Pagham Beach (Holdings) Ltd

Application ref: P/84/12

New access road and amendment to curtilage of plot 1

Amendment to approval P/44/09 (re-submission, following Refusal P/30/12)

PLAN NO 598/10B  
SCALE 1:200  
DATE 03/09

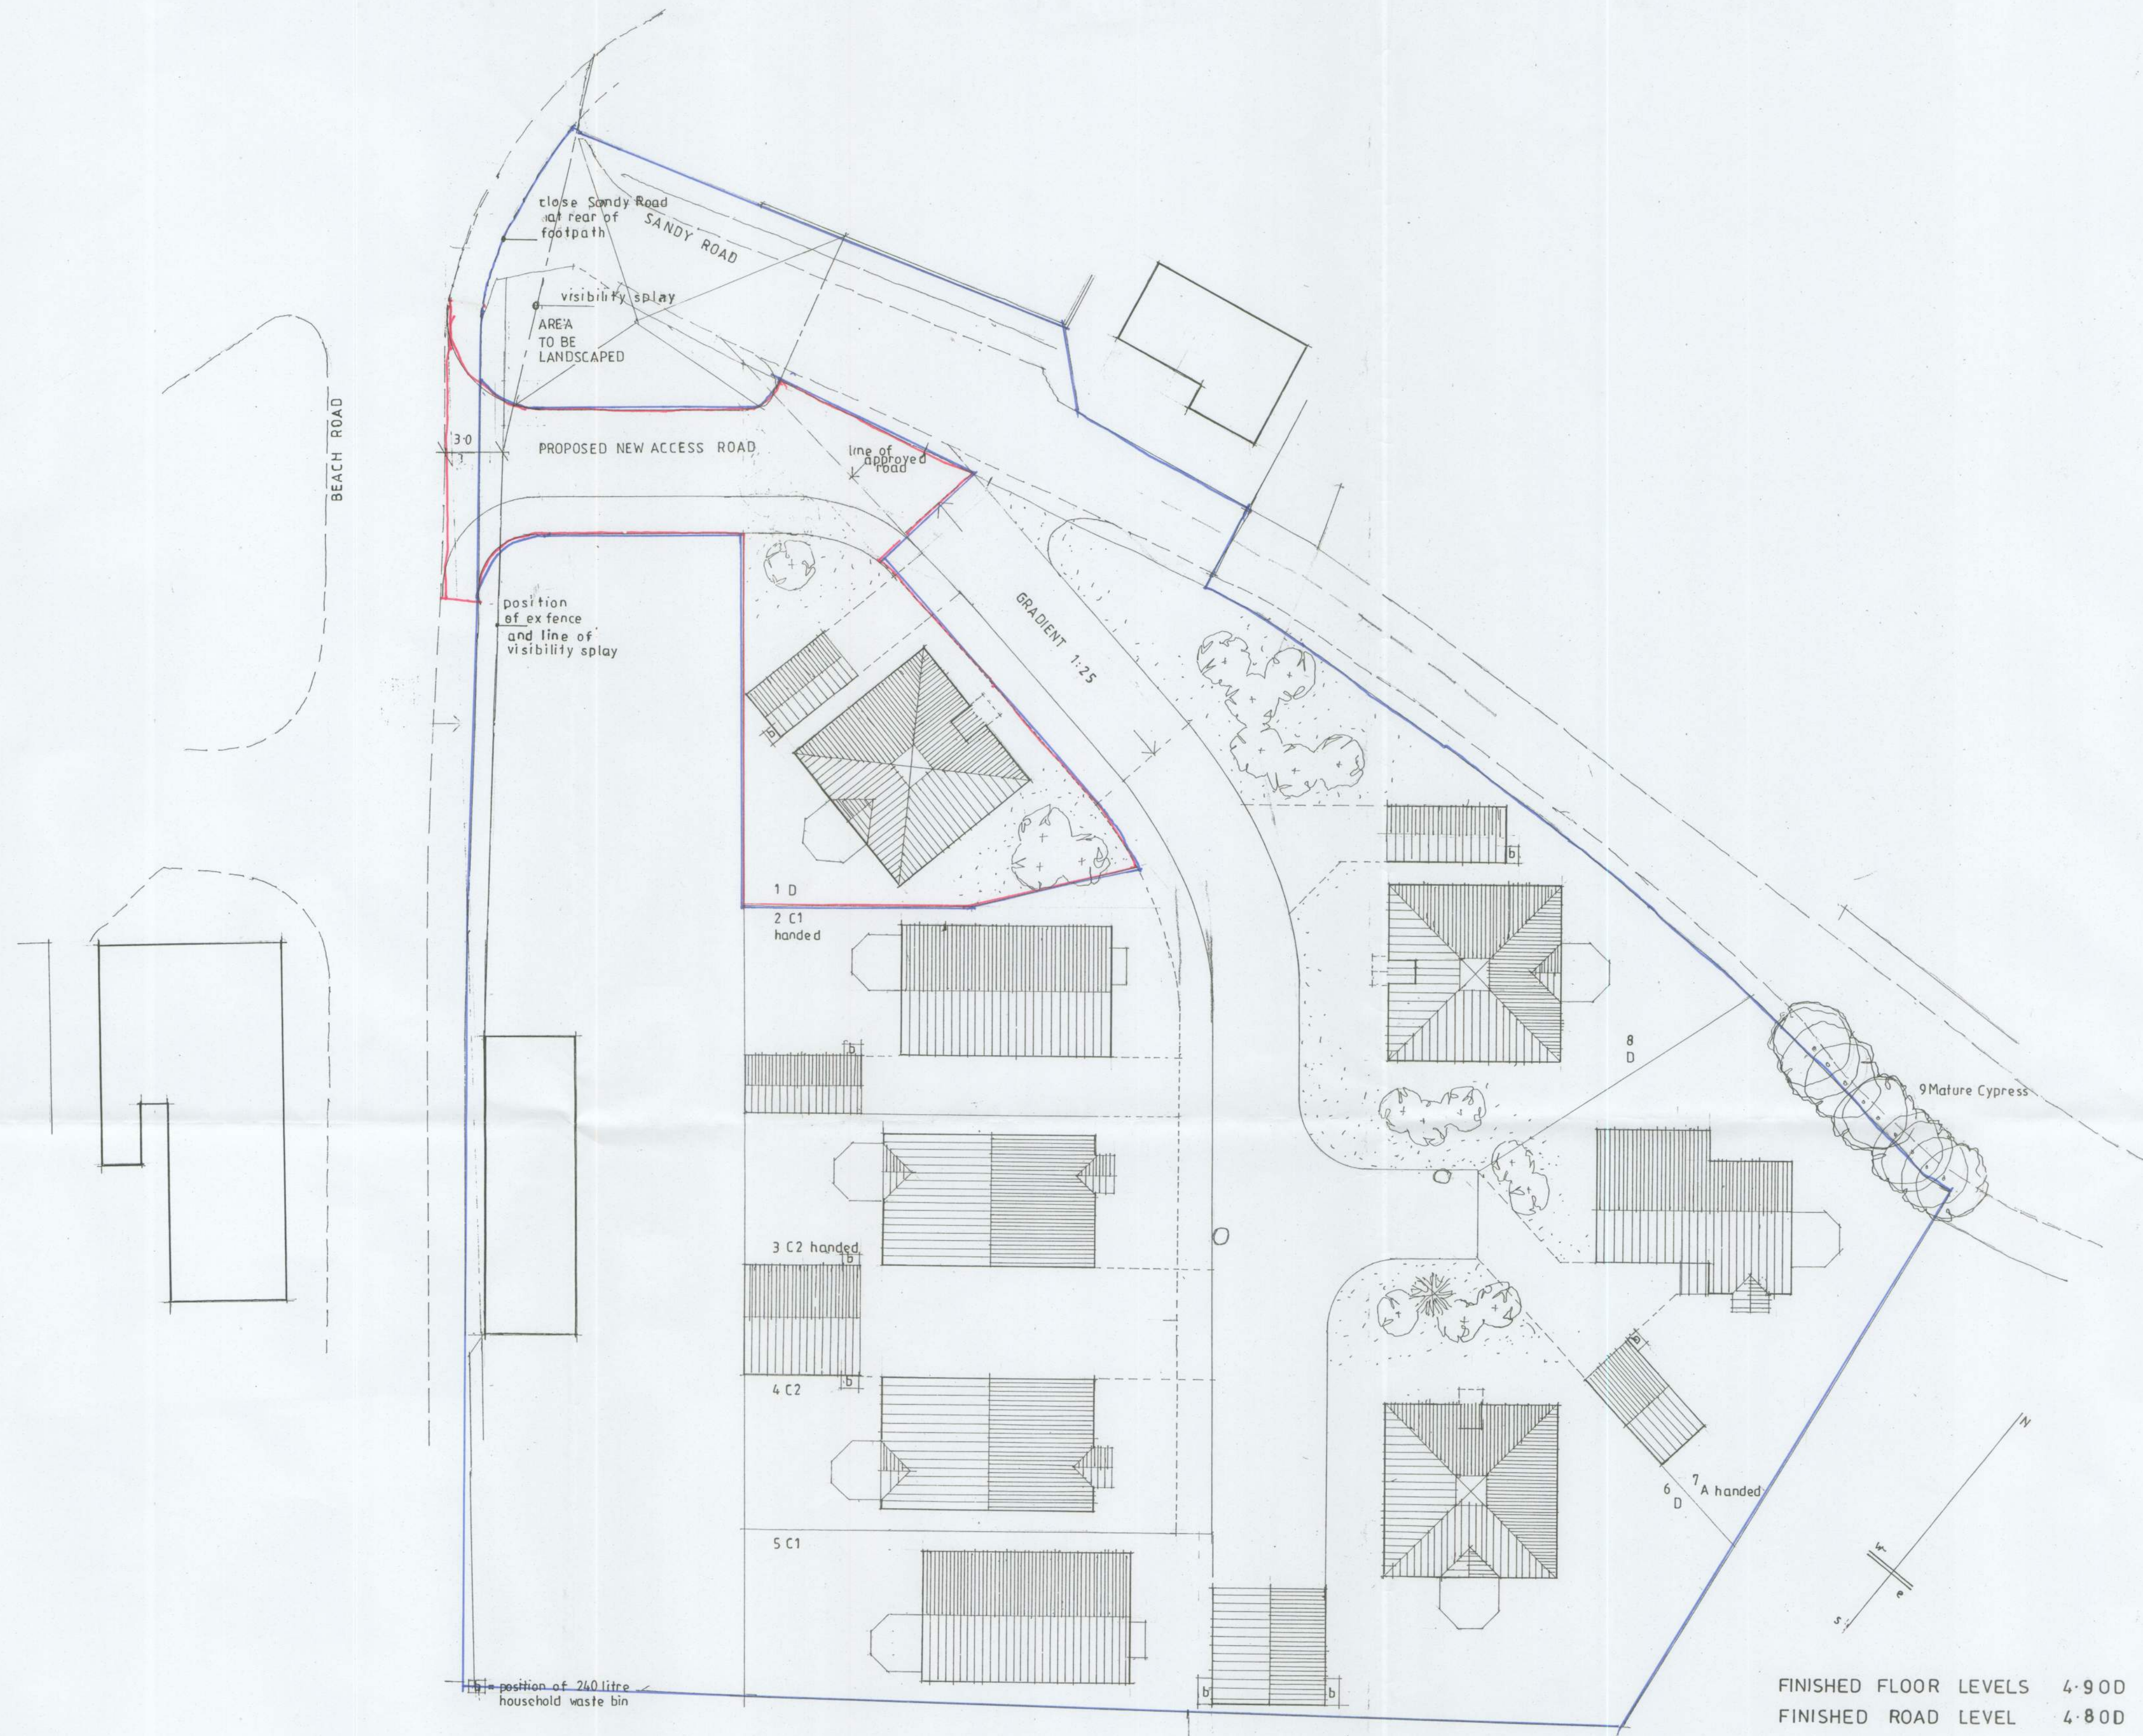
2. The above application refers to the closure of the existing Sandy Road/Beach Road junction and the proposed landscaping of the redundant road access and associated areas. However, those areas are not included within the Application Site and are merely outlined in blue as being in the applicant's ownership or control. Please confirm that the Planning authority will be able to control any Conditions that it may seek to impose on this area of land outside the Application Site, as it would seem that the extent of the Application Site should be amended to include those areas cross-hatched on the applicant's Drawing no. 598/11.

3. The vision splays on the new junction to Beach Road are not defined, which surely should be included in the Application Site, to ensure that the applicant has adequate control of these important areas, and that the Planning Authority can seek to impose Conditions protecting these areas for public safety.

5. The junction of Sandy Road to the new estate road is not defined within the application and it is requested that this information is provided, to ensure that an appropriate layout and safety provisions are incorporated for both vehicular and pedestrian access.
